# Non-Material Amendment Details

**Site:** 102-124 Station Road, Edgware HA8 7BJ

**Job No:** 14775-1

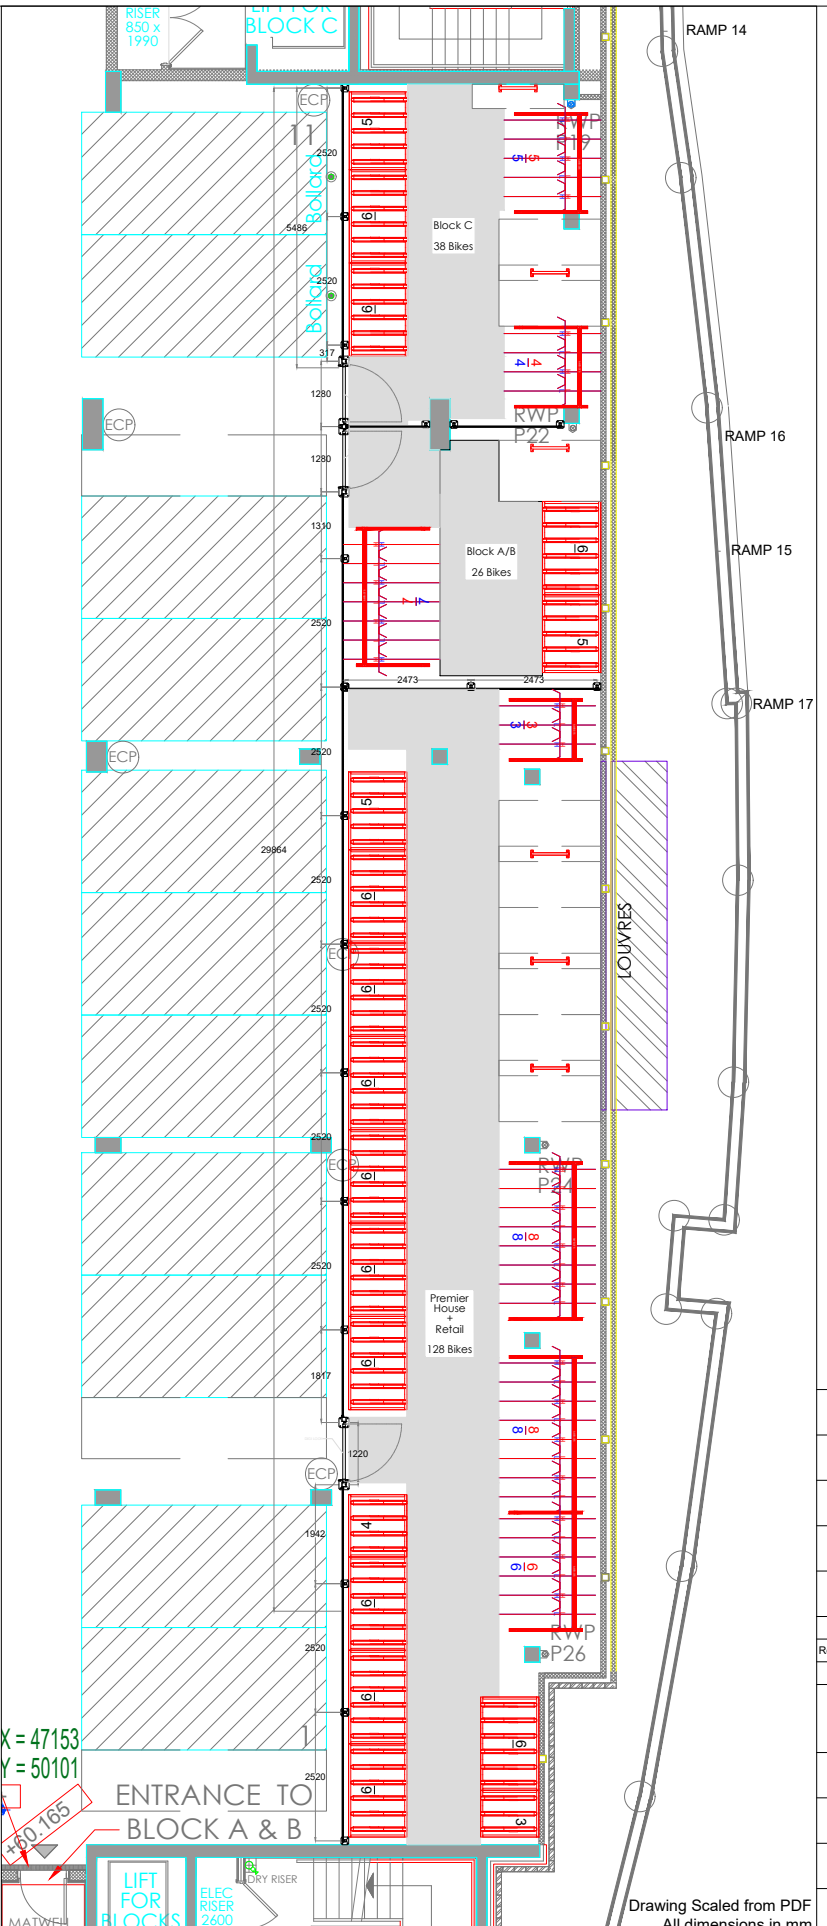
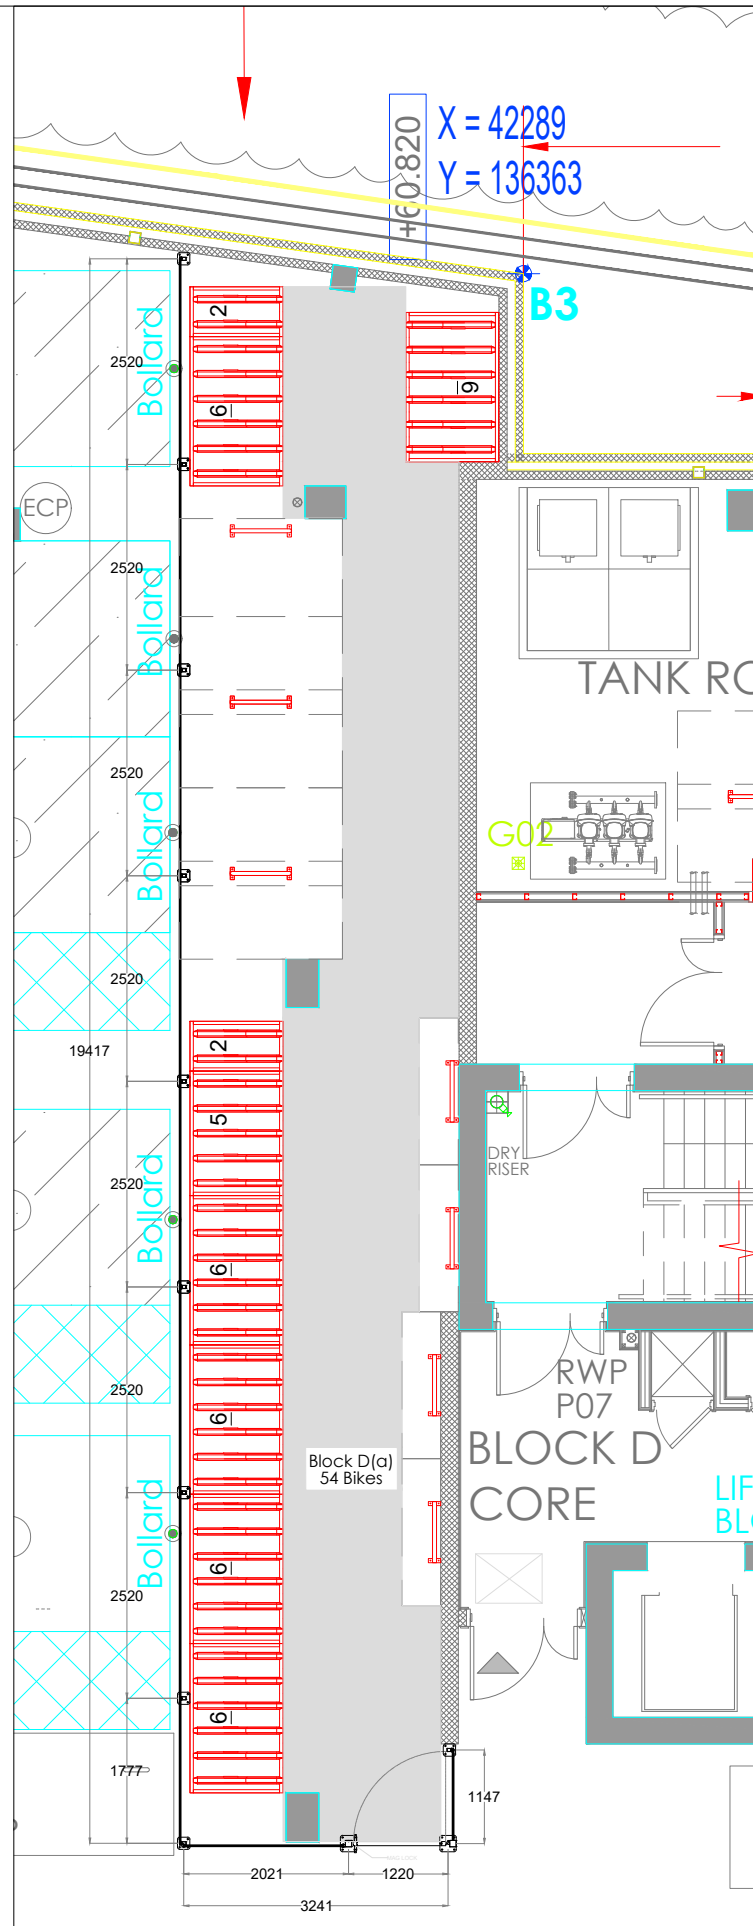
The ground floor block D cycle store has 54 spaces and Improvements have been made to the cycle storage at the ground floor level generally. The required area has been rationalized and is now housing a mix of cycle stands to suit all needs. Dual height cycle storage racks, semi vertical racks and Sheffield stands to all storage areas.

Drawing Title	Proposed Ground Floor Plan	
Job-Dwg No	14775-1 / 101	Rev
		C

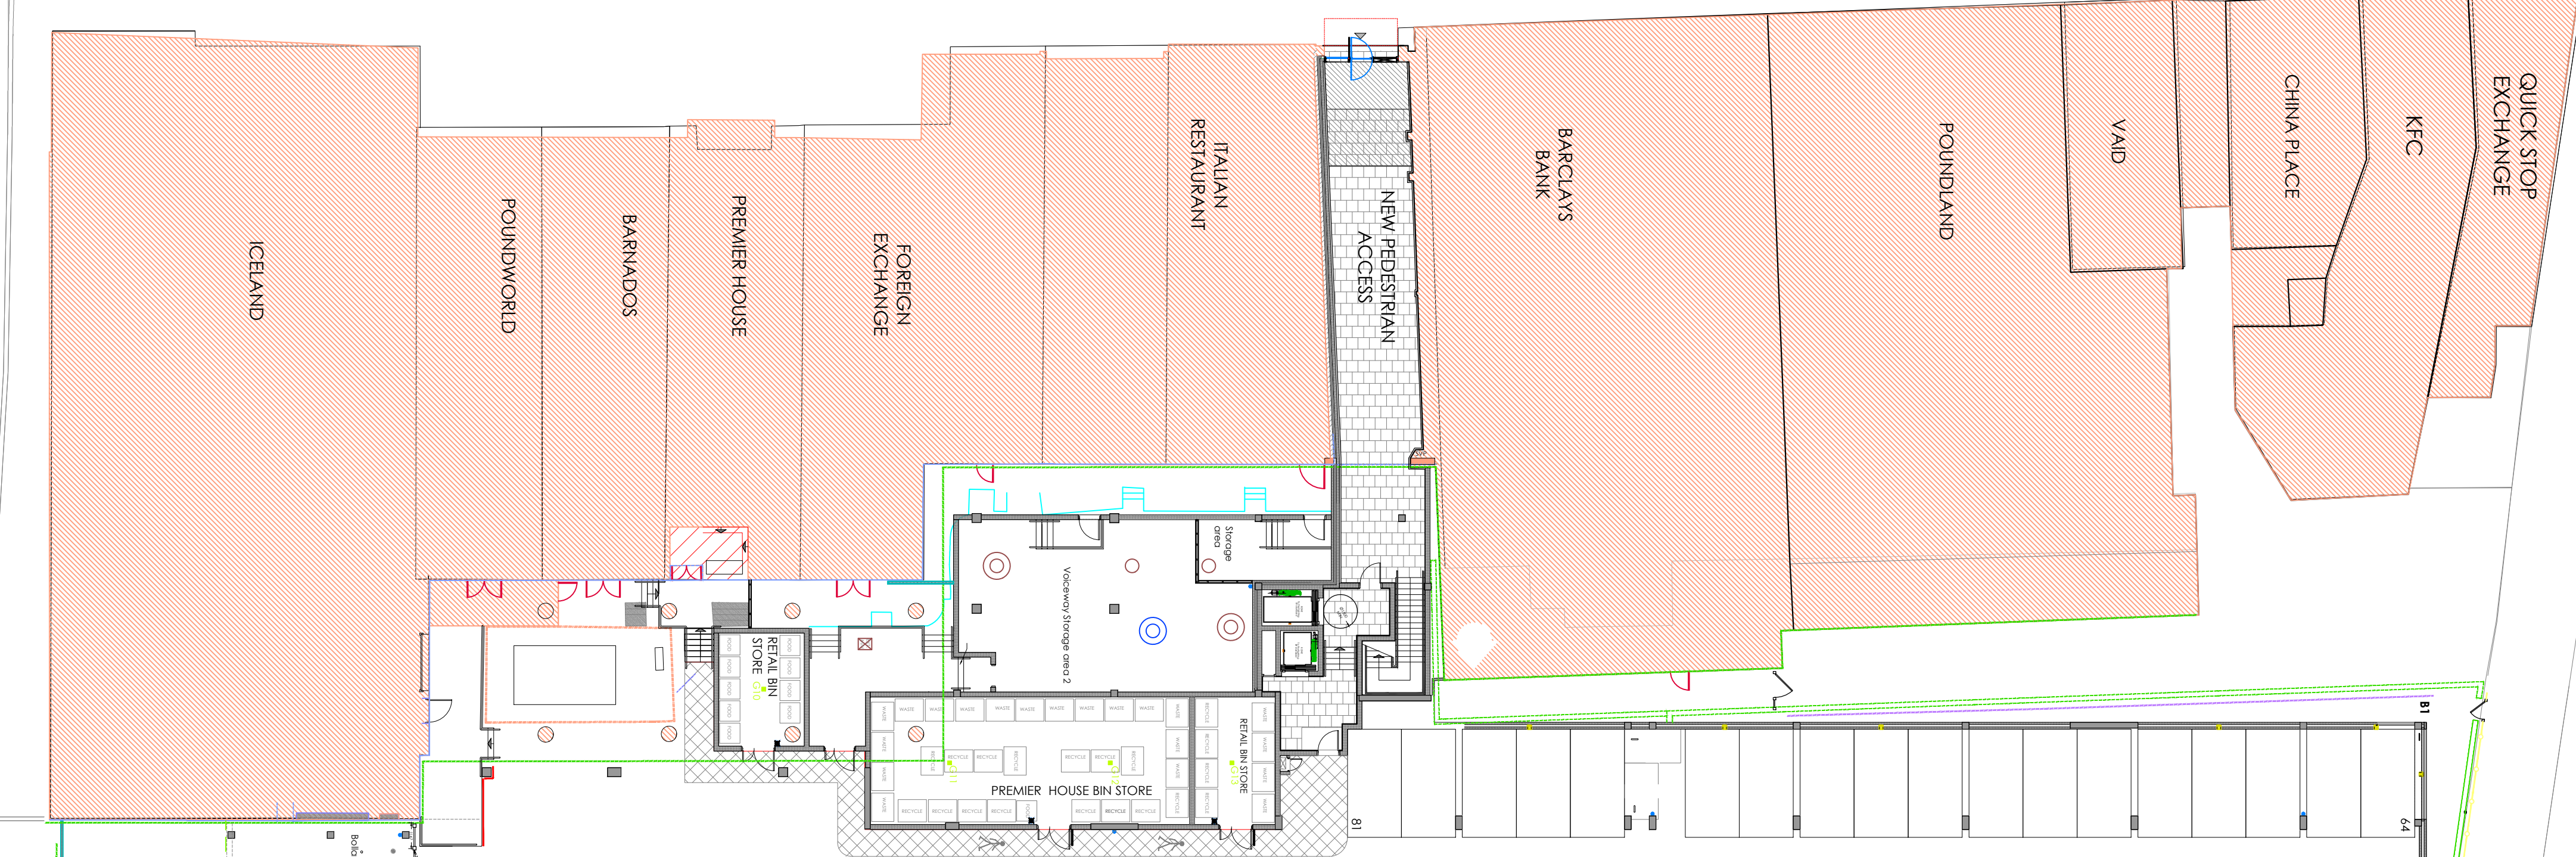
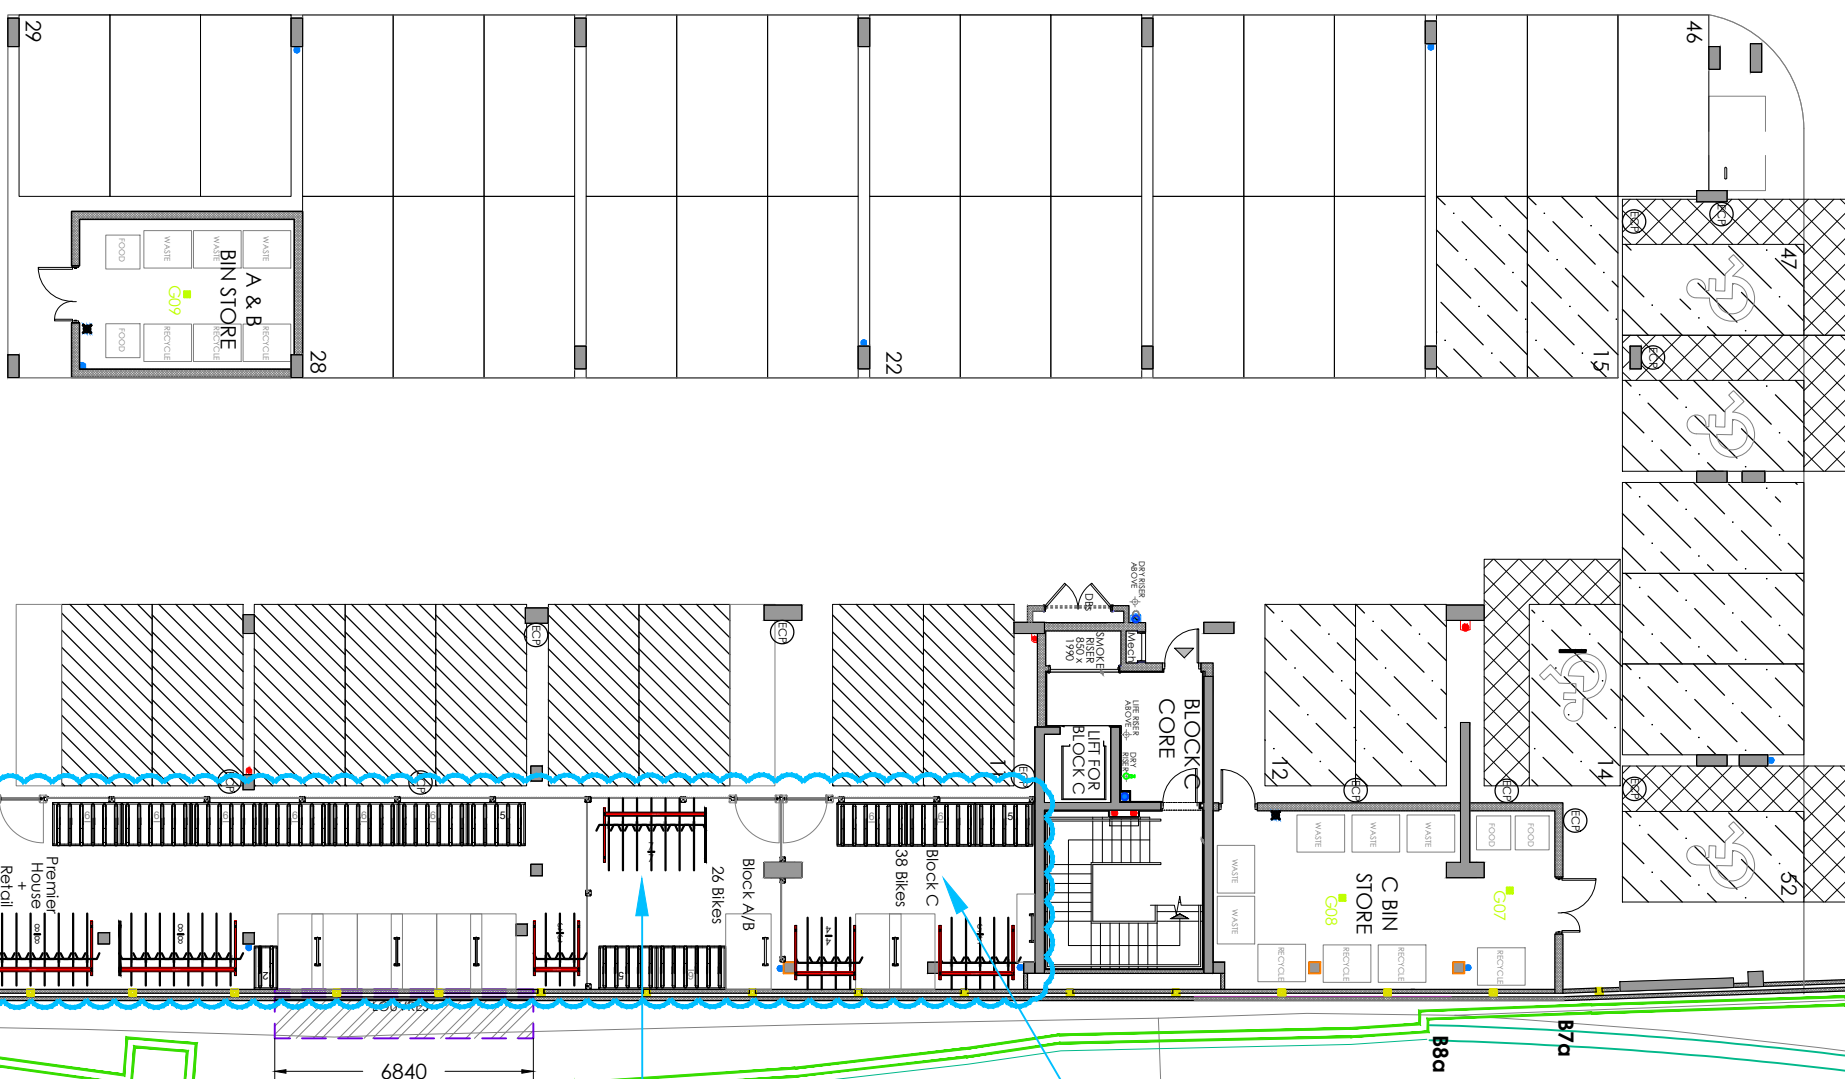
Total cycle spaces have increased from 132 to 140 spaces for block D. The remaining block are as per the original space requirements.
